Your ref:	133_20 Manchester Street	Please reply to:	Fraser Fikrie
Our ref:	24/01739/FULL	Tel No:	0753424 7967
		Fee Queries:	0207 641 6500;
		Email:	planningreception@westminster.gov.uk;
Mr Peter Gal 4H Architecture D S Burge and Co. Ltd The Courtyard 7 Francis Grove London SW19 4DW United Kingdom		Incomplete Applications Town Planning & Building Control City of Westminster PO Box 732 Redhill, RH1 9FL	
		21 March 2024

Address: 20 Manchester Street, London, W1U 4DJ,

Proposal: Replacement of front elevation windows with Laminated timber sash windows; refurbishment to first, second and third floor flats; and associated works. (Linked with 24/01740/LBC)

Sash window - Laminated option (9mm)

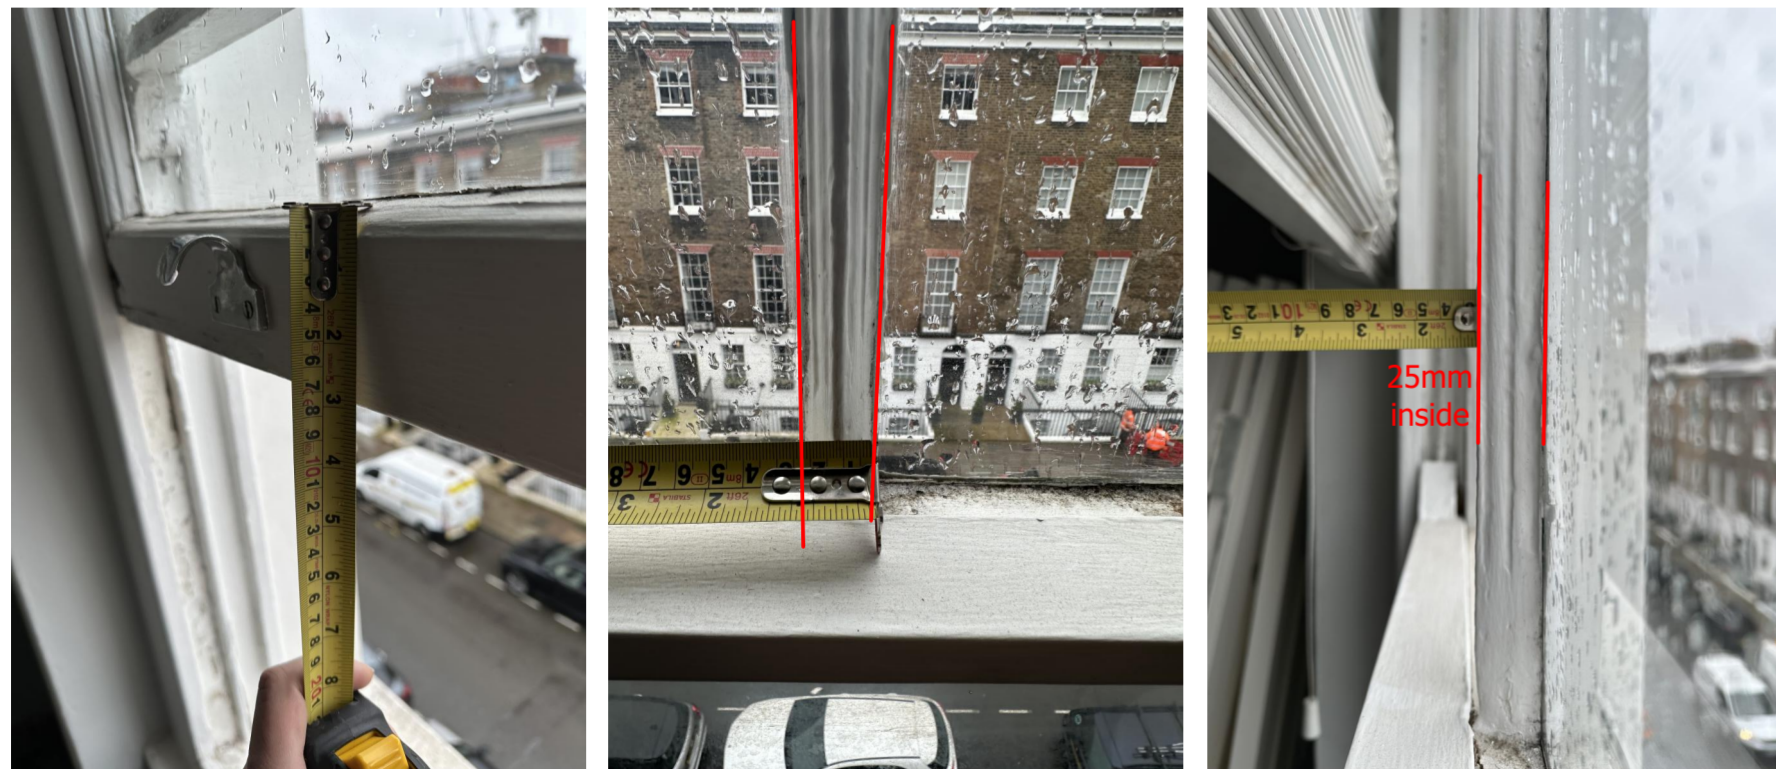
- 2 Your application includes multiple options of windows; drawing no. 133_910_PL01 includes option of 'Sash window - Laminated option (9mm)' and 'Sash window - Single glazed option (4mm)'.

We can only deal with one option per application. Please amend the drawings/documents as necessary and confirm which drawings/option that form part of this application.
